The request being submitted to El Paso County is seeking approval of an application for a final plat known as the Trails at Aspen Ridge Filing No. 4. The proposed final plat is for 124 single family detached units, utilities and open space. This final plat filing is a continuation of the Trails at Aspen Ridge development project as illustrated on the Trails at Aspen Ridge PUDSP (PUDSP191). The parcel is currently vacant and suitable for development.

PHASE NO. 4
 VICINITY MAP
 JUNE 2021

TRAILS AT ASPEN RIDGE	
 Excellence by Design	
2435 Research Parkway, Suite 300 Colorado Springs, CO 80920 Contact: Nicole Schanel Phone (719) 575-0100 Fax (719) 575-0208	
FILING NO. 4 VICINITY MAP	
JUNE 2021

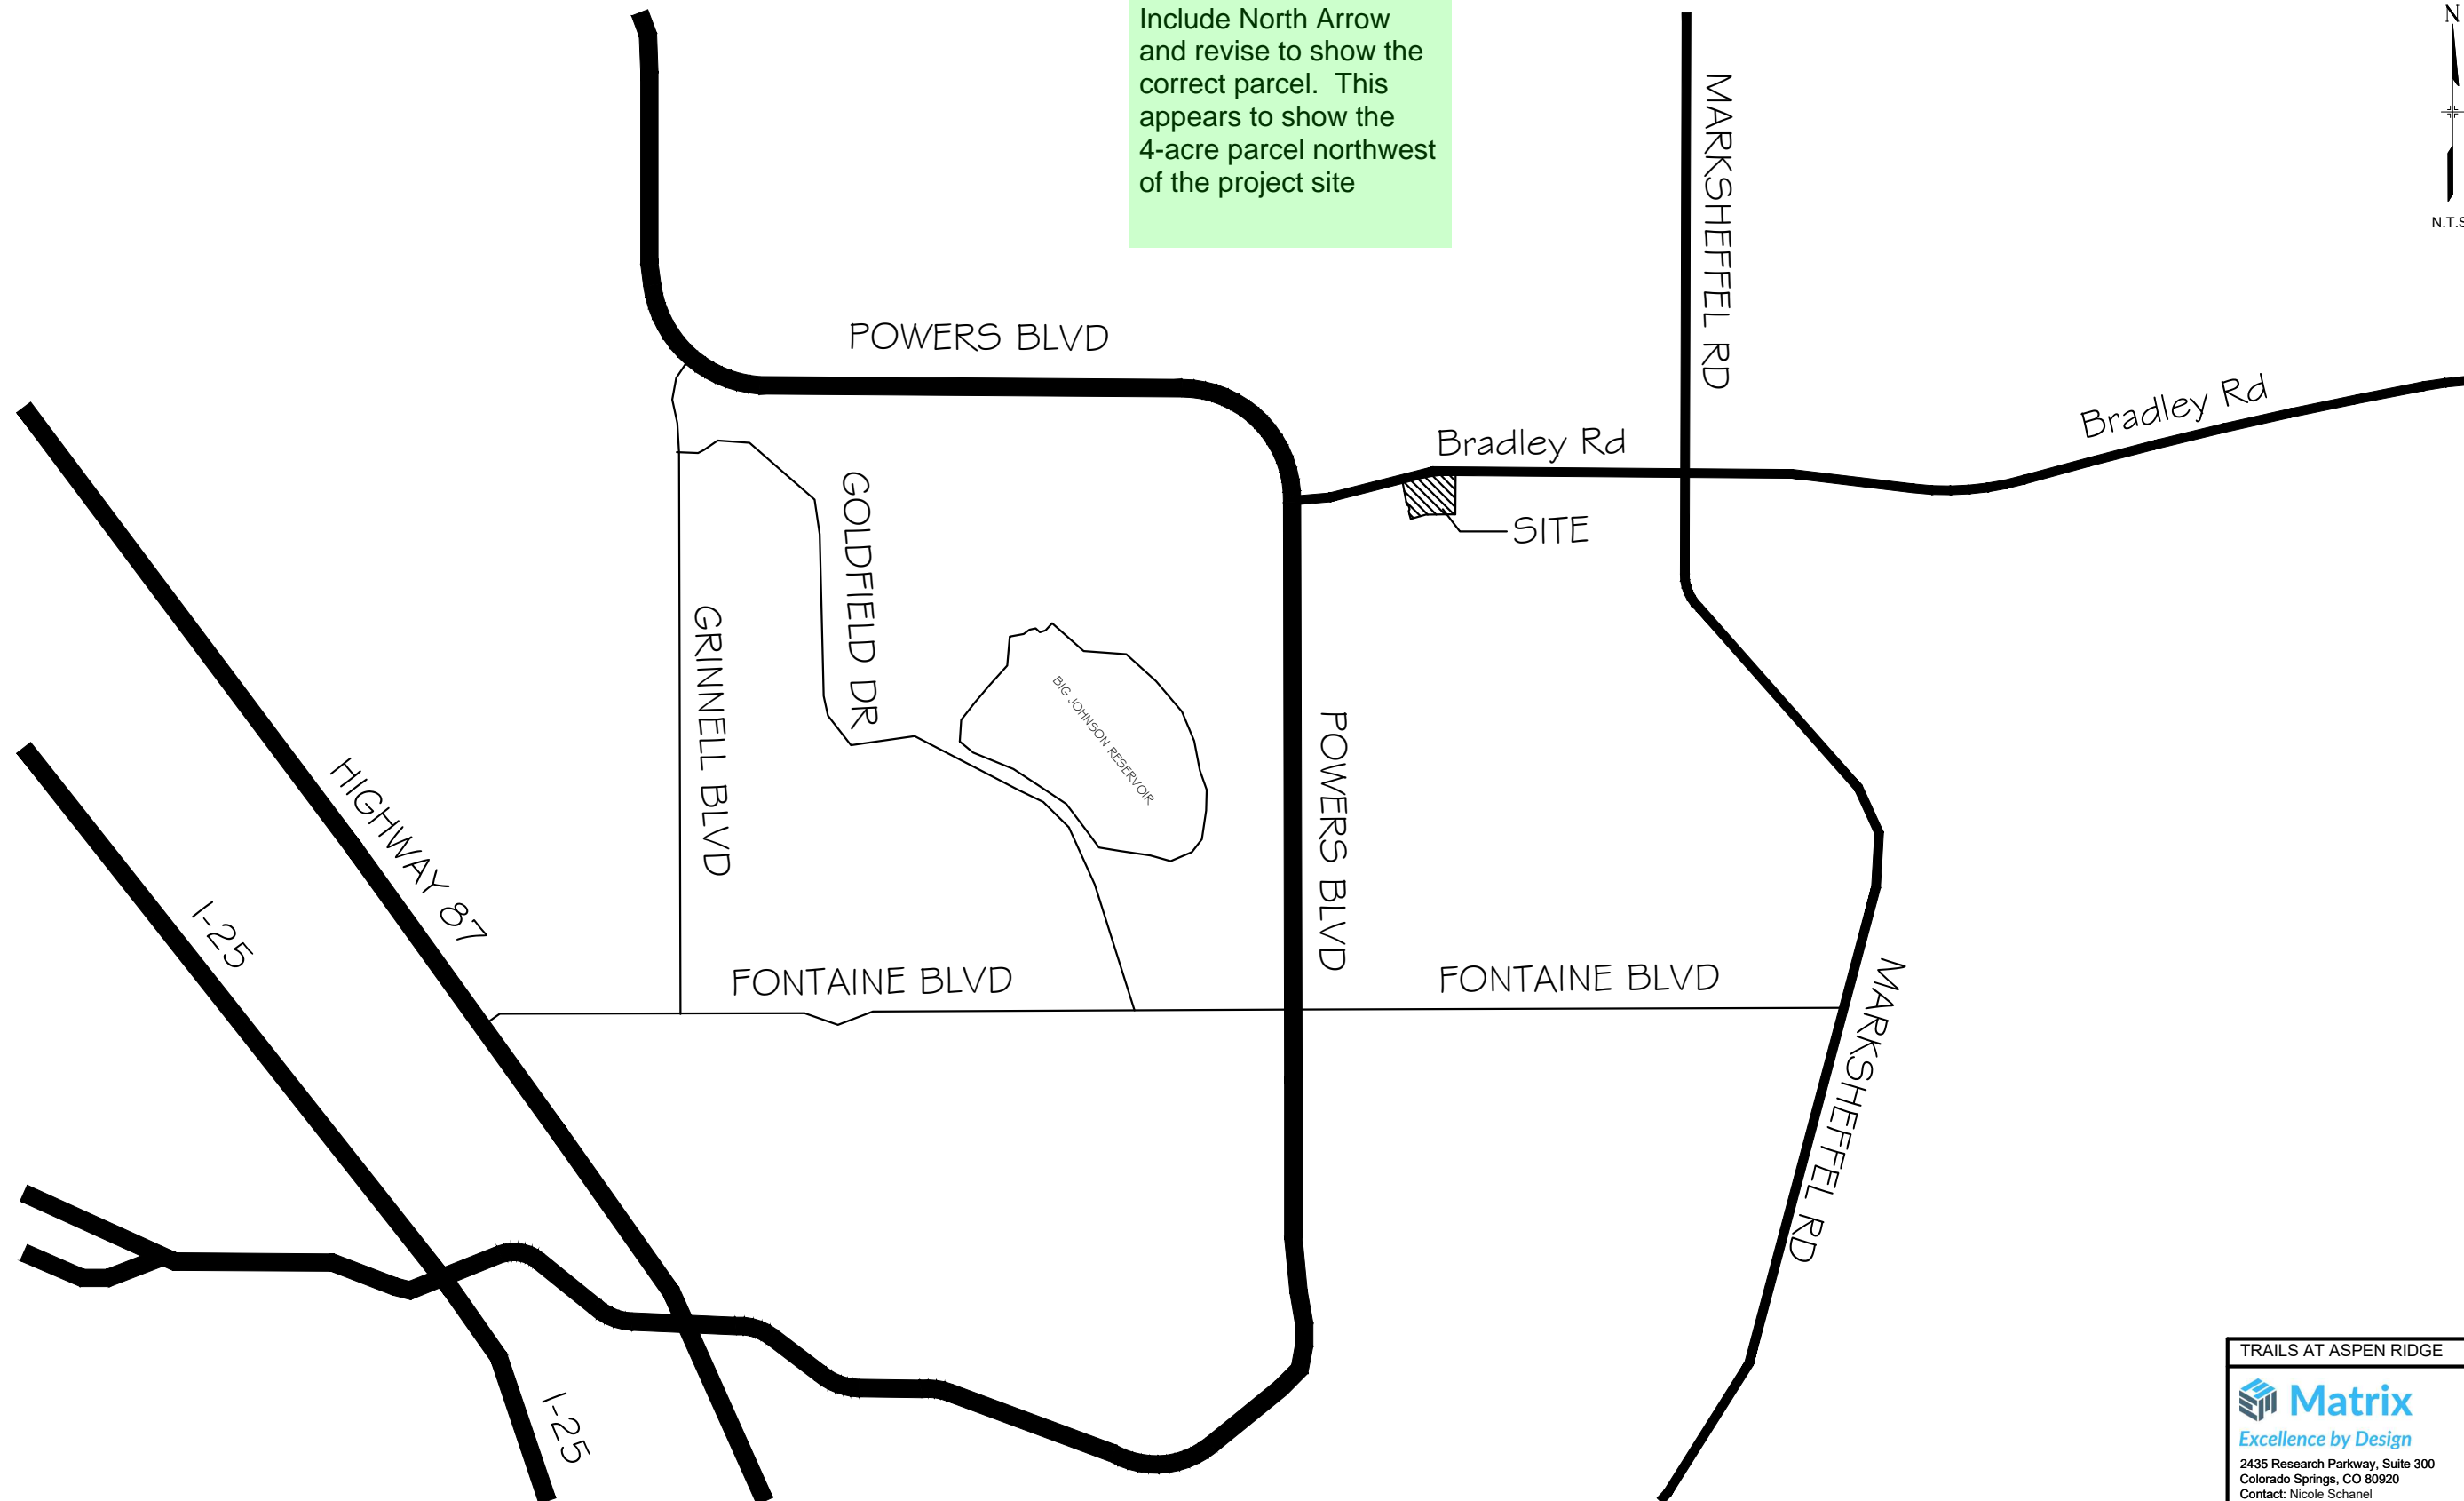
Include North Arrow and revise to show the correct parcel. This appears to show the 4-acre parcel northwest of the project site

this is the correct location of the site. the commercial sites are further west.

north arrow was included with original map
